CITY OF ALBUQUERQUE

February 9, 2022

Re: Kidz Academy
7800 Sage Rd SW
30-Day Temporary Certificate of Occupancy
Transportation Development Final Inspection
Engineer's/Architect's Stamp dated 1-20-21 (M10D020)
Certification dated 2-1-22

SITE PLAN
SCALE: 1" = 20'-0"

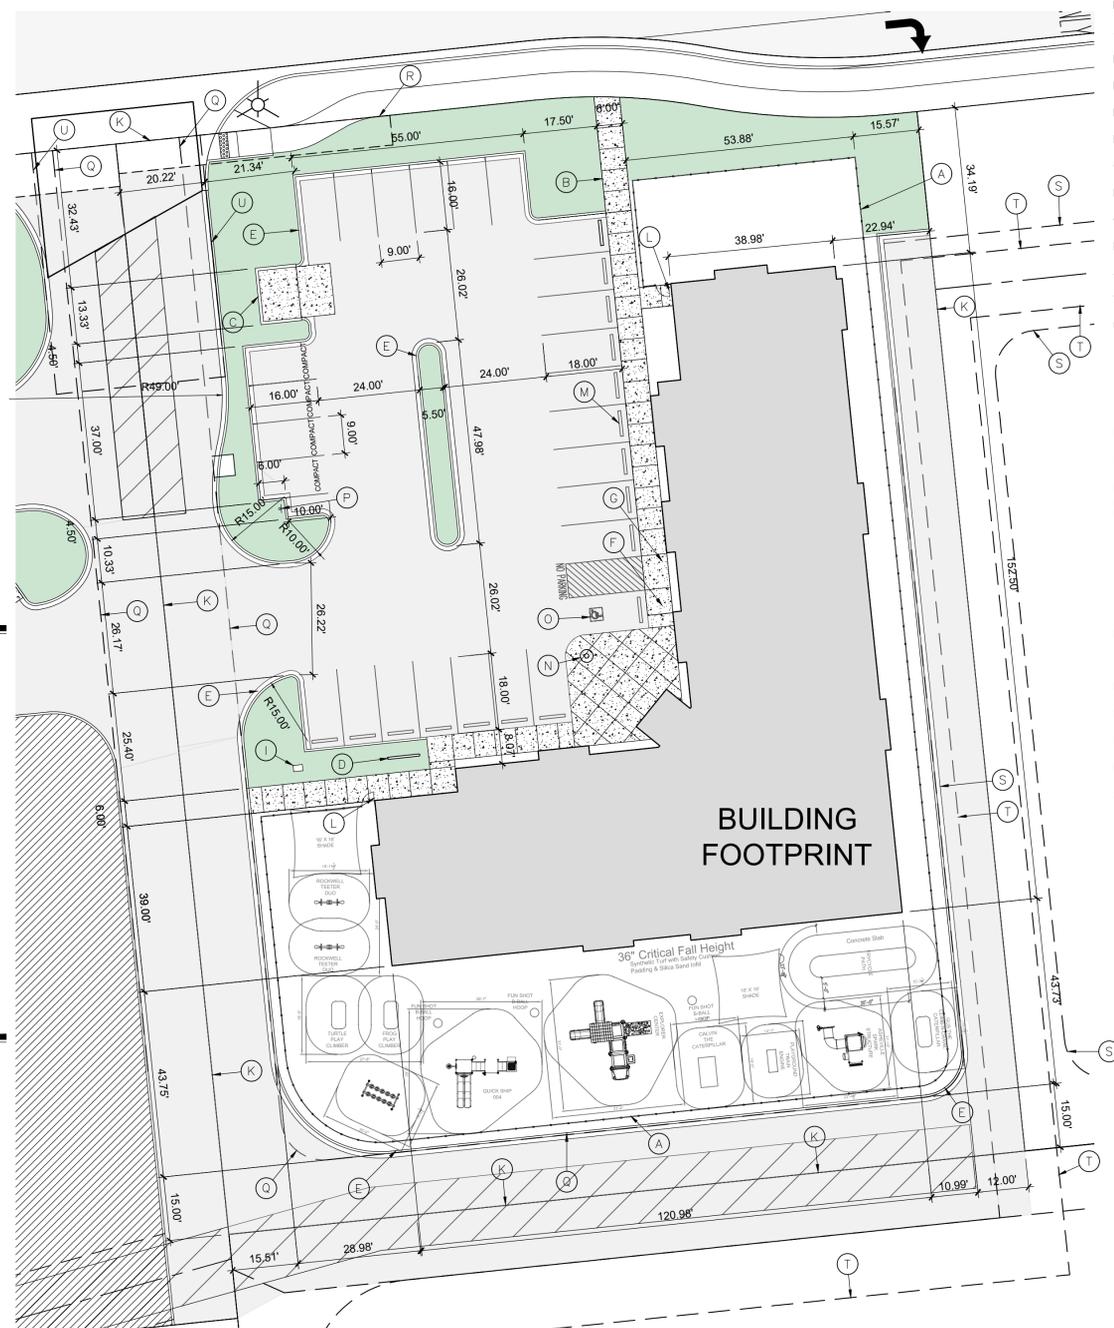
- Missing a portion of the sidewalk connection? Please see redlined plan for location.
- A section of Curb and Gutter was not installed? See redlined plan for location
- Please add bike rack & remove construction debris and equipment from site.
- Add "COMPACT" floor markings to all compact parking stalls.
- Paint the fire lanes.

Once these corrections are complete, email pictures showing the changes to epgomez@cabq.gov for release of Final CO.
